DEVELOPMENT REVIEW BOARD  
SUPPLEMENTAL SUBMITTAL

PROJECT NO. 2018-001579

SUBMITTAL DESCRIPTION: Departmental comments indicated a number of items to be addressed in a deferred hearing date, indicated above for multi-family apartments project at 7500 Indian School Rd in the Winrock Town Center. Responses to the comments and revised sheets are provided.

This letter outlines the modifications that have been made to the Apartments at Pennsylvania St and Indian School Rd application for a major site plan amendment to the approved Winrock Town Center Site Development Plan (PR-2018-001579) to address the agency comments that were received.

**CONCEPTUAL UTILITY PLAN**

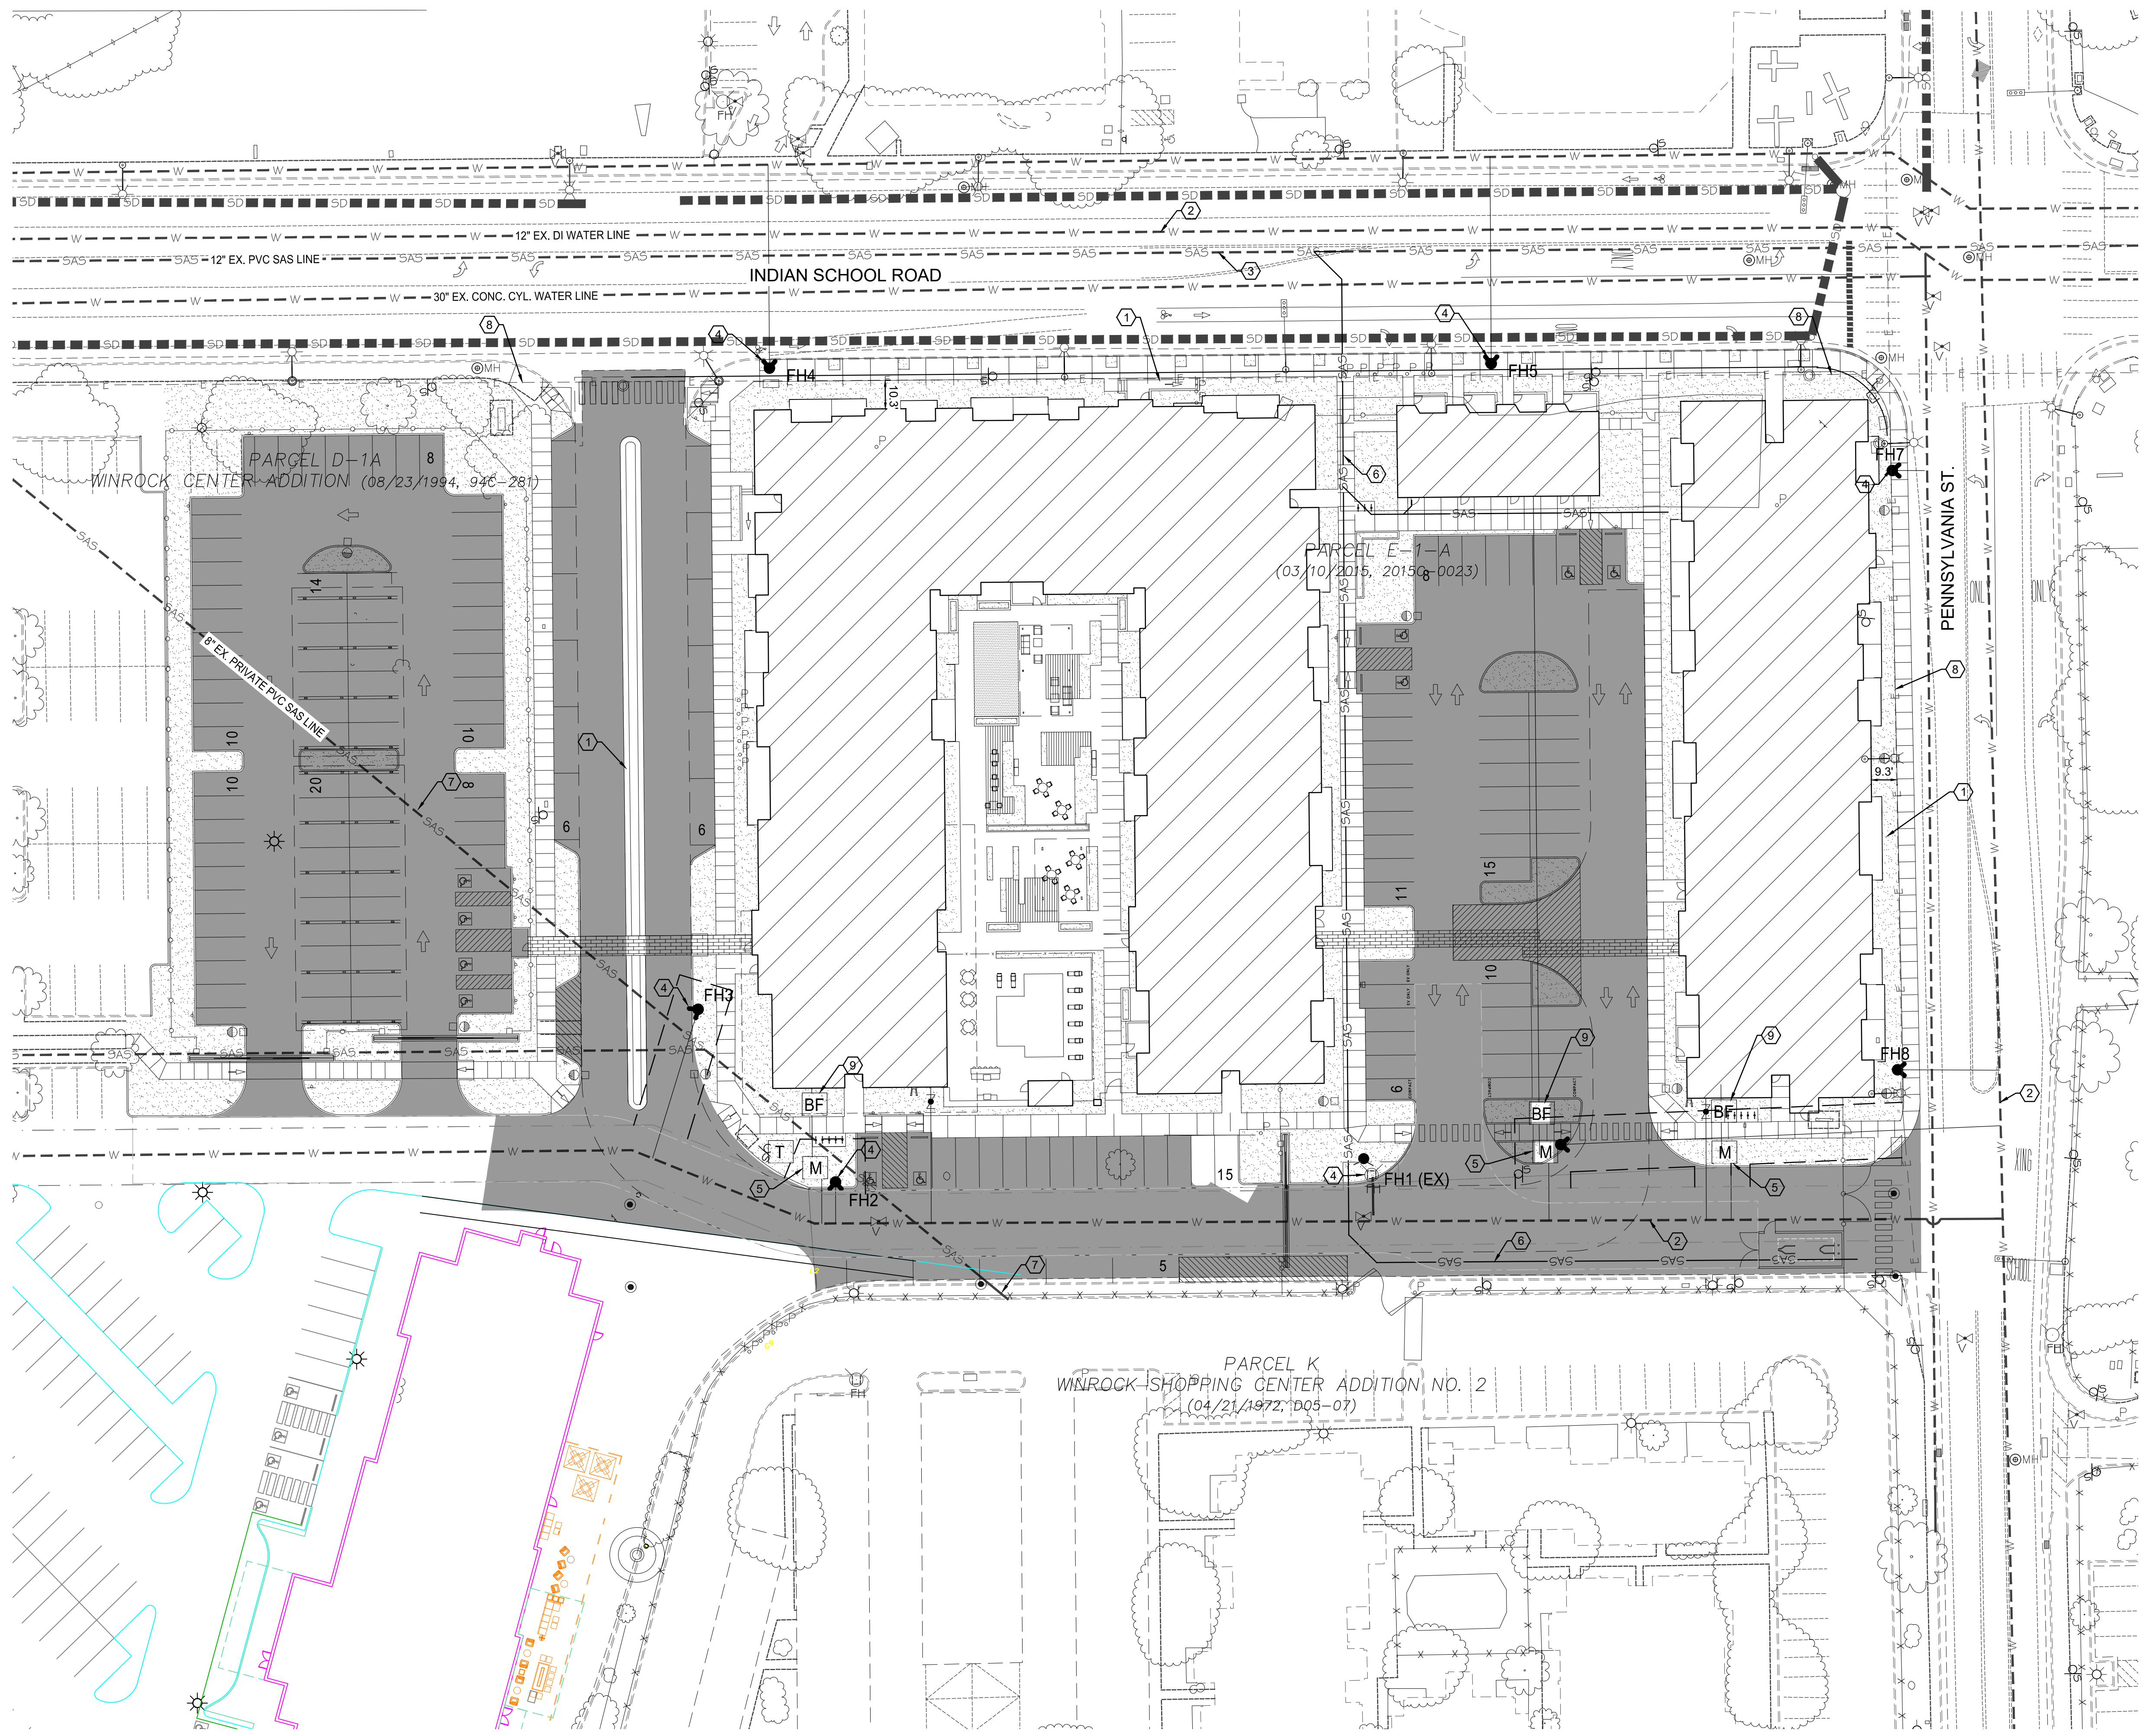
2. Please label the northernmost existing waterline in which FH5 is connecting to.  
*Annotation added.*
    3. **PREVIOUS COMMENT:** Please label existing waterlines along Pennsylvania St. FH7 and FH8 are connecting to different waterlines along Pennsylvania St. The 16" well collector along Pennsylvania St. is not suitable for connection.  
*Annotation added.*

- a. Updated utility plan shows two backflow preventers on the same line. Also, the domestic service does not show a connection point to any waterline. Please label connection points to public waterlines as there is quite a bit of linework making it difficult to follow.

- a. Label this FH. Response to comments indicated FH#6 but this is not labeled.

- a. All proposed fire hydrants onsite shall be labeled as private. Fire hydrants in public right-of-way shall be labeled as public.

- a. Please label the sanitary sewer as being private  
*Proposed sanitary sewer line has been labeled as private.*

*Linework has been revised and relabeled.*

*Annotation added.*

*Concur*

City Project No. **XXXX.XX**      Zone Map No. **J-19**      Sheet **C400** Of

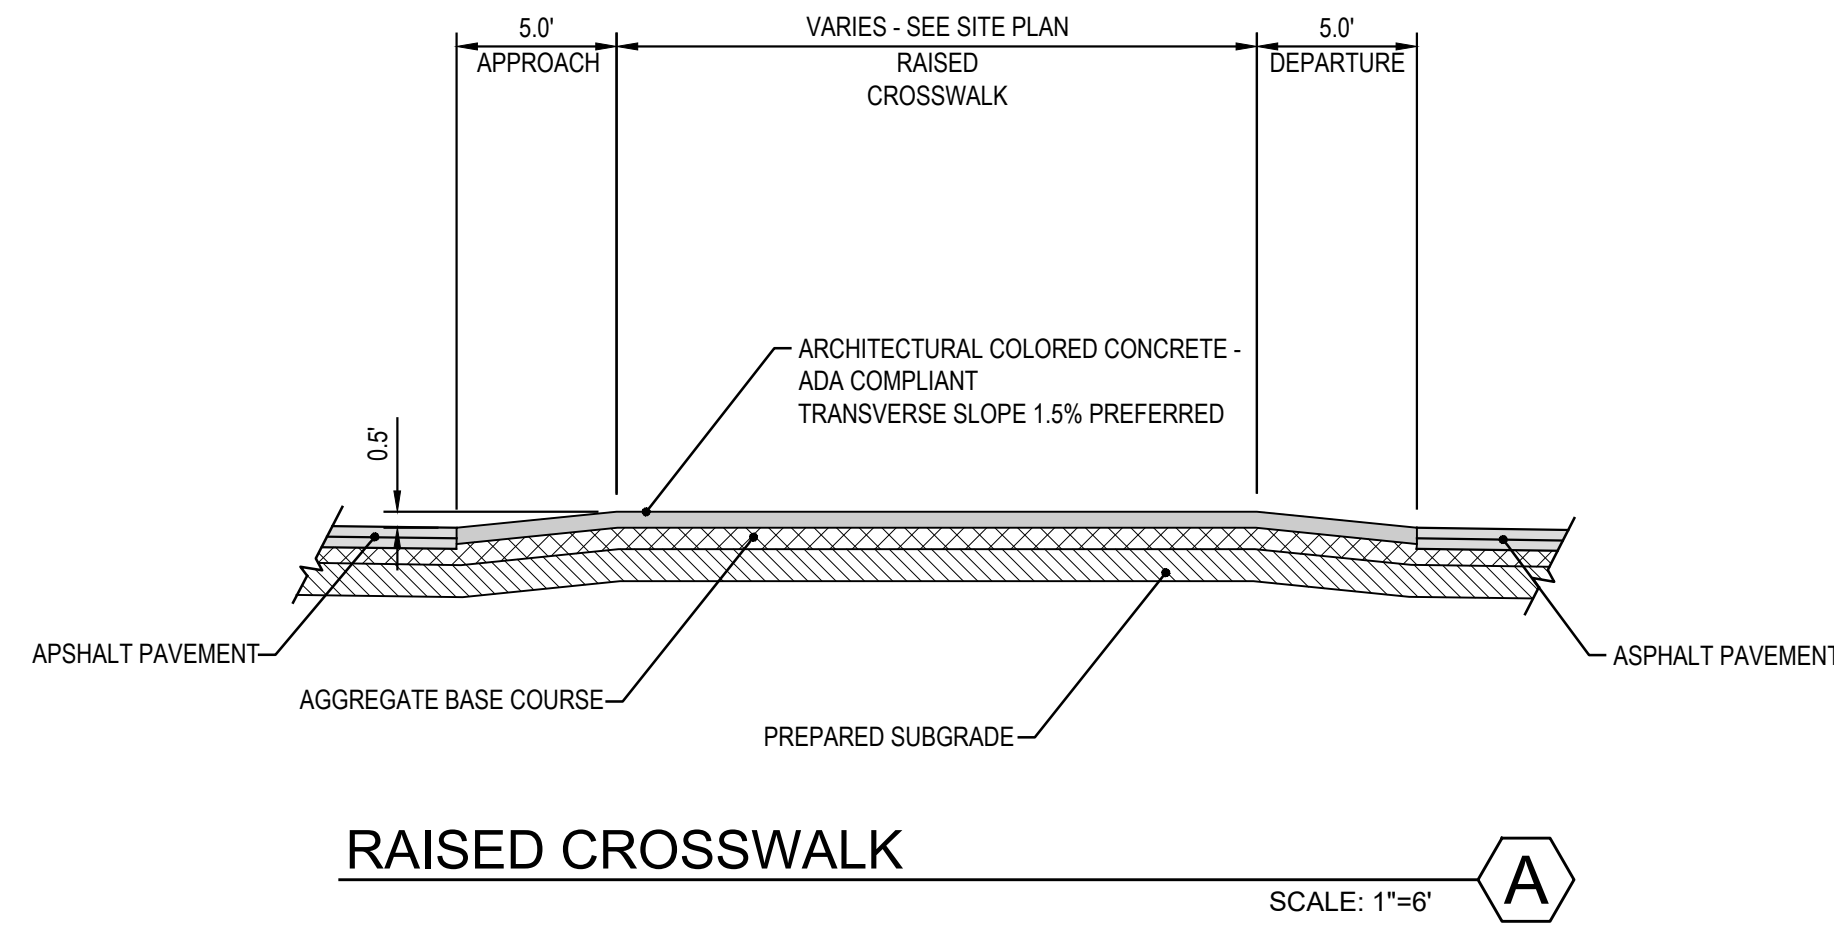
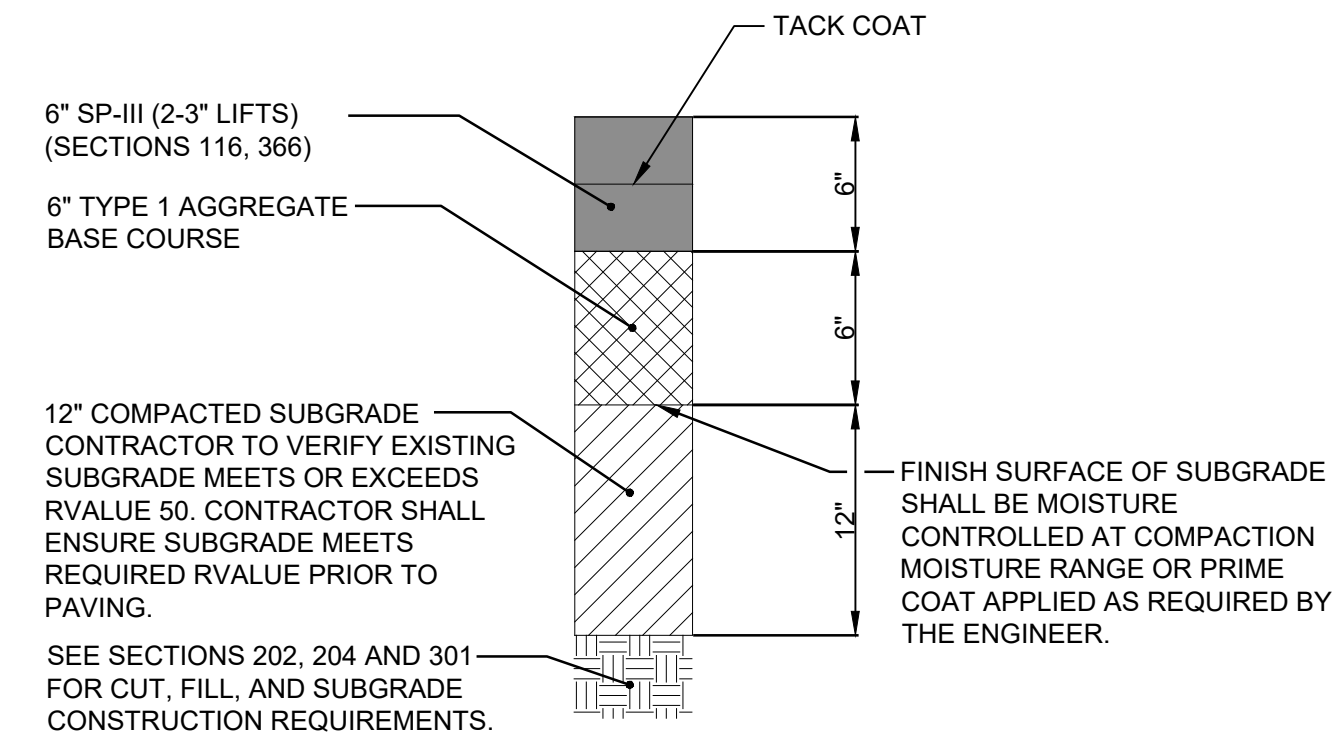
3. For road exiting onto Indian School Road, show a cross-section. Used a keyed note for striping and include a note for the centerlane lane as well. Show proper transitioning. Call out pavement arrows, and provide dimensioning for the lanes.

7. Call out width of raised crosswalk on the detail provided.

7. PREVIOUS COMMENT: What is the horizontal clearance between the proposed private sanitary sewer along the south property line and the existing public waterline? Is the appropriate clearance provided? Is the proposed sanitary sewer encroaching into the public waterline easement?

- b. The response to comments indicated the existing public waterline easement is shown but that is not the case. Please show and indicate if the private sanitary sewer encroaches the existing public waterline easement which is not allowed.

*Keyed notes for asphalt striping and directional arrows have been added. Road cross-section was added to sheet C400.*

*Raised crosswalk width has been labeled and road cross section added to sheet C400.*

*Cross-section added Sheet C400.*

*The easement is labeled and cross-section added to Sheet C400.*
